Ms Zoe Toppin
Case Officer
Planning Application AW/161/21/T
Arun District Council Planning Office
6 June 2021

Comments regarding Planning Application AW/161/21/T

REF 1

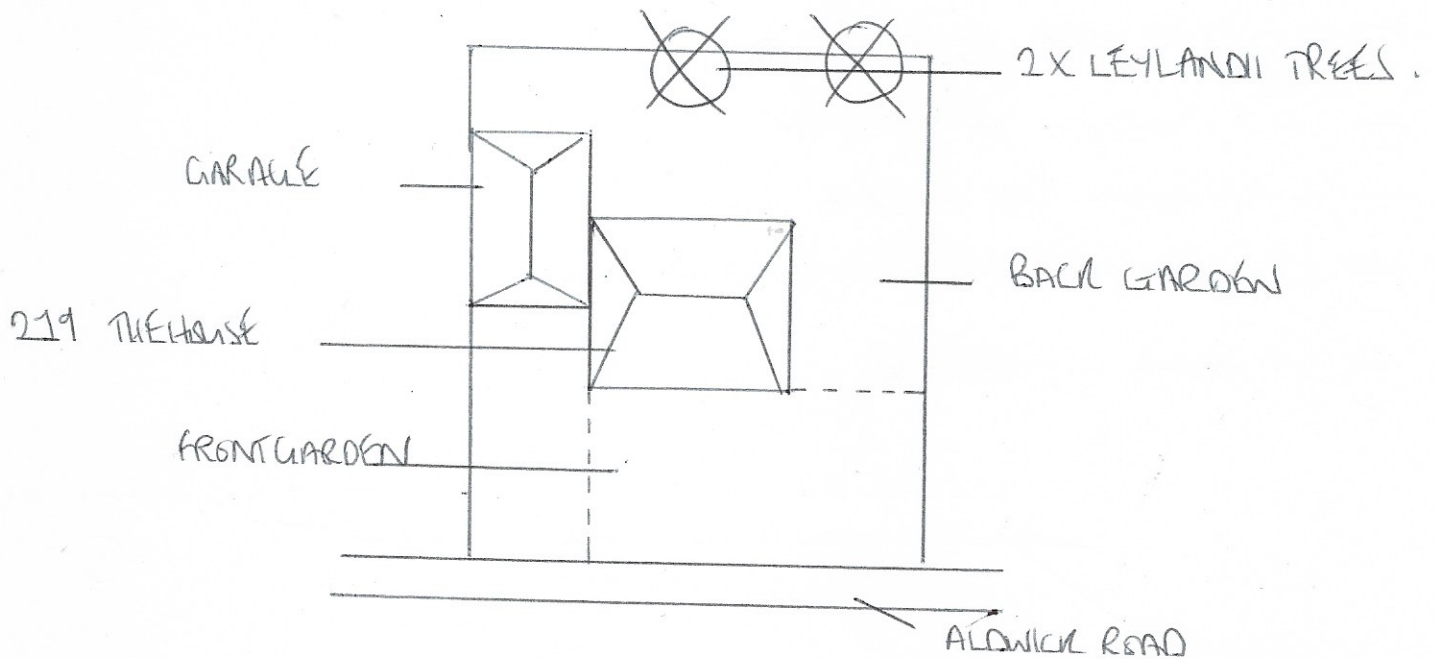
Whilst welcoming the height and lateral reduction I would request that permission for any lateral reduction apply to all sides of the trees.

These trees were last cut back five years ago but only on one side which has left the corner tree, in particular, unbalanced on my side of the boundary. It's long flailing branches already overhang my property by 7 metres and worry me in strong winds.

I have spoken with Mr Taylor expressing my desire to reduce the width of the trees on my side (and on behalf of my neighbour at number 16) by the same 2.5 metres to restore overall shape and balance after his side has been completed.
